AW-312-14-HH – 37 Kingsway – further objections – 8-2-2015

FURTHER OBJECTIONS TO AW/312/14/HH – 37 Kingsway – extensions – within the Craigweil House Conservation Area and Area of Special Character

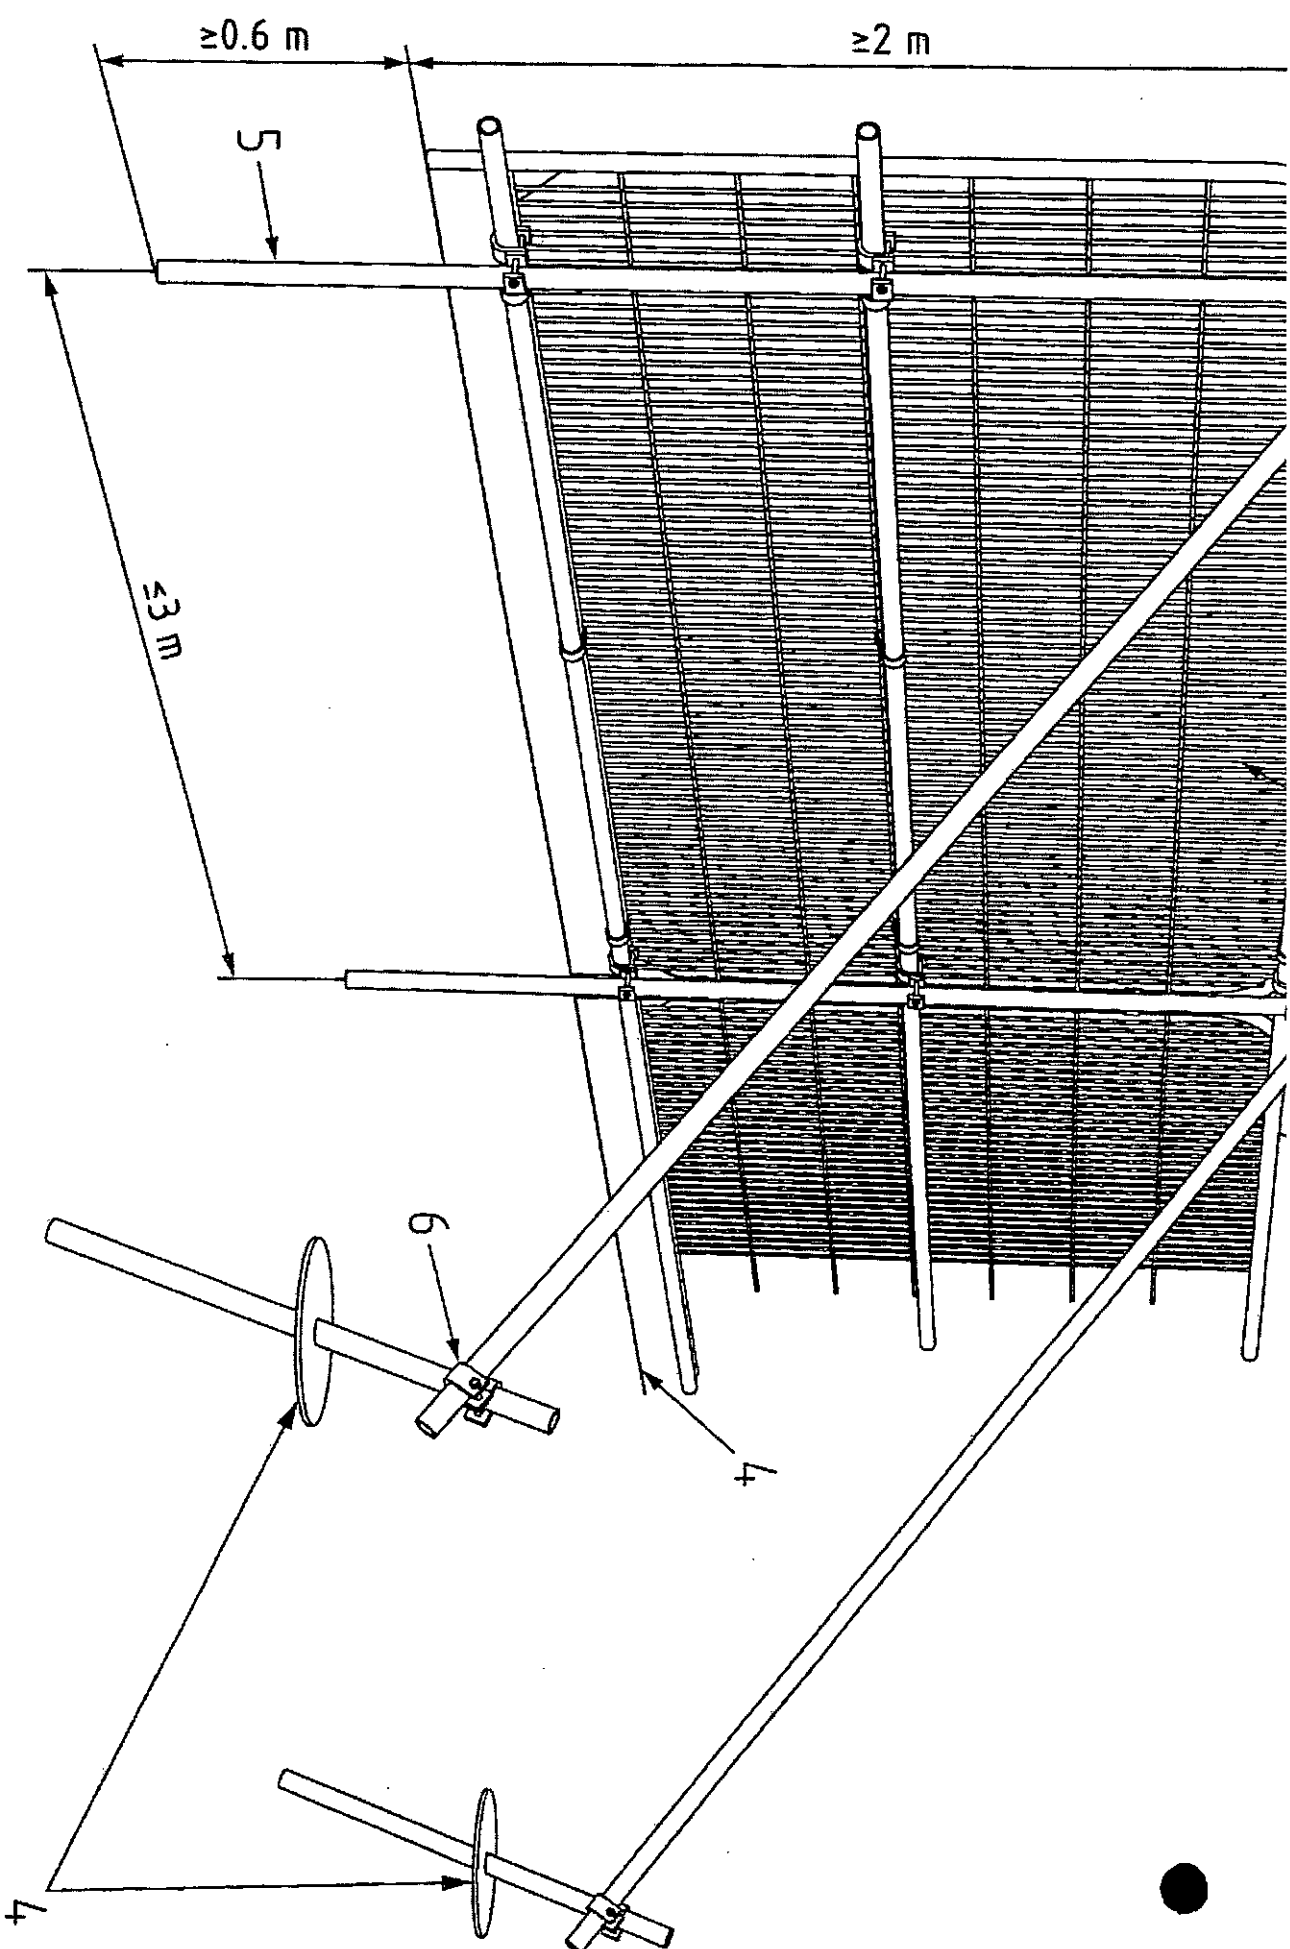
8. The inclusion of the diagram extracted from BS5837:2012 is useful to explain how boundaries must be protected as sacrosanct from before construction works commence to after their completion and it served the purpose of begging the question of the applicant as to how he can even erect this – before starting on any conservatory or wall – and then dig footings! The supporting barriers will not be going in the garden of No. 39 because Mr. and Mrs. Houlton will not permit this invasion of their property. It is difficult to understand how it can be fixed in the existing reinforced concrete driveway, which must be removed for the placing of ground slab, and retained until the construction is completed **but this will no doubt be explained in the three BS Plans properly and admirably sought by the Tree Officer.**
